Our Ref: A/95/18/HH
Your Ref:

Town & Country Planning Act 1990 (as amended)
Town & country Planning (Development Management Procedure) (England) Order 2015
Application for Planning Permission for Works or Extension to a Dwelling

Development Single storey rear extension.
Location 7 Harrison Crescent Angmering

Block Plan: 1:500

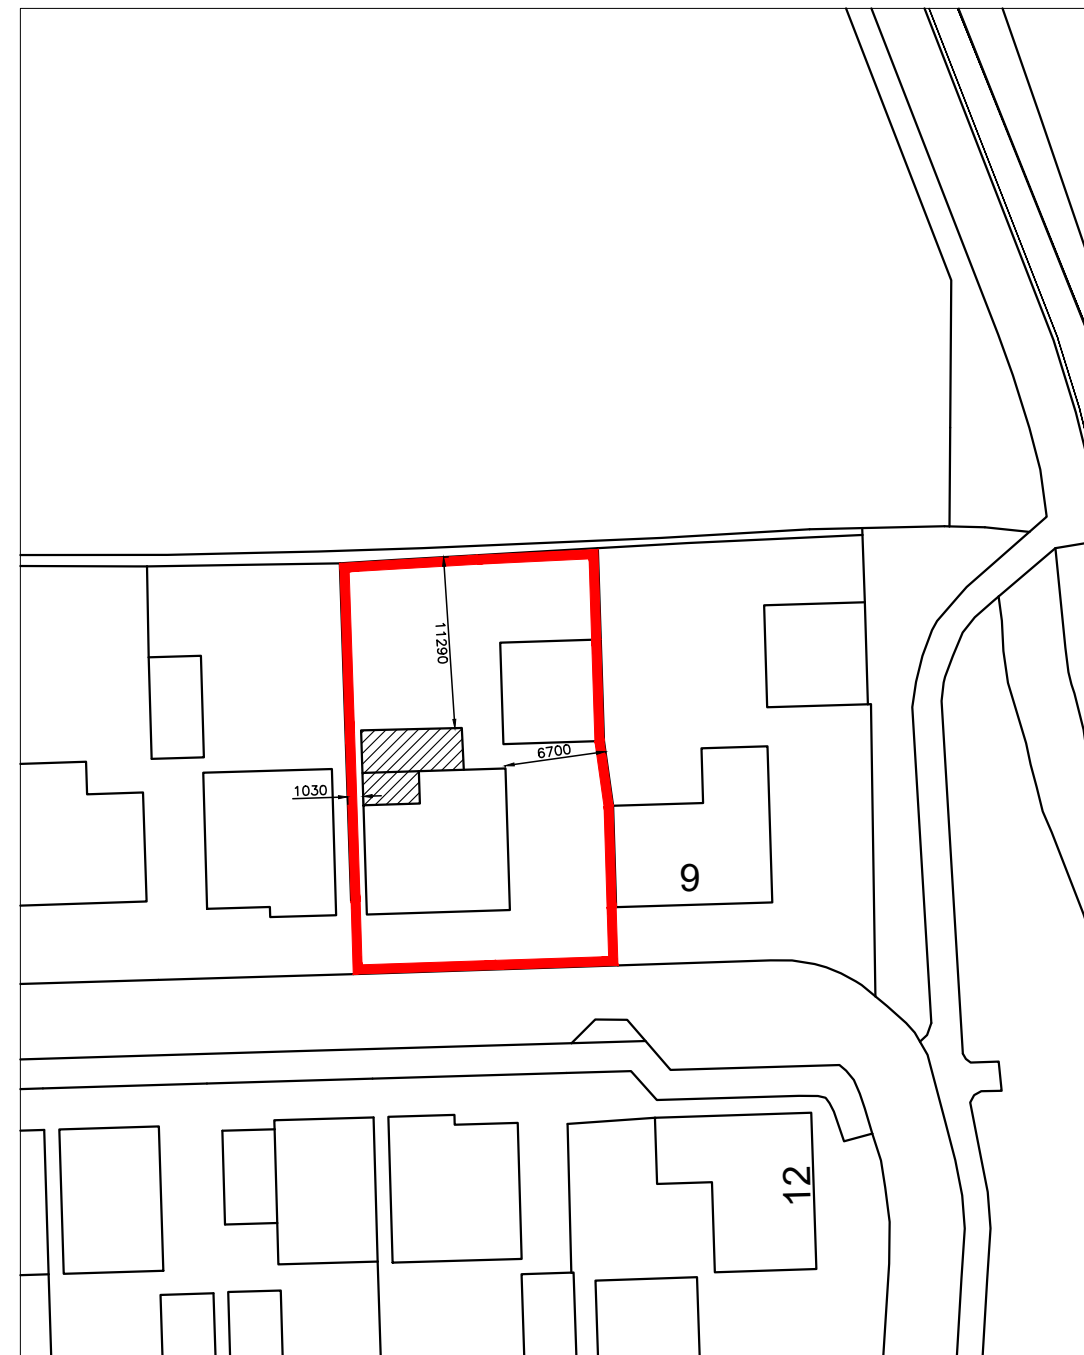
Block Plan - REVISED

Please submit 1 electronic or 3 paper copies of a revised block/site plan at a scale of 1:500 or 1:200 with the proposed dimensions clearly indicated from the proposals to the site boundaries and to include 1 named road. Further details of what must be included on the plan can be found in the National Validation Requirements.
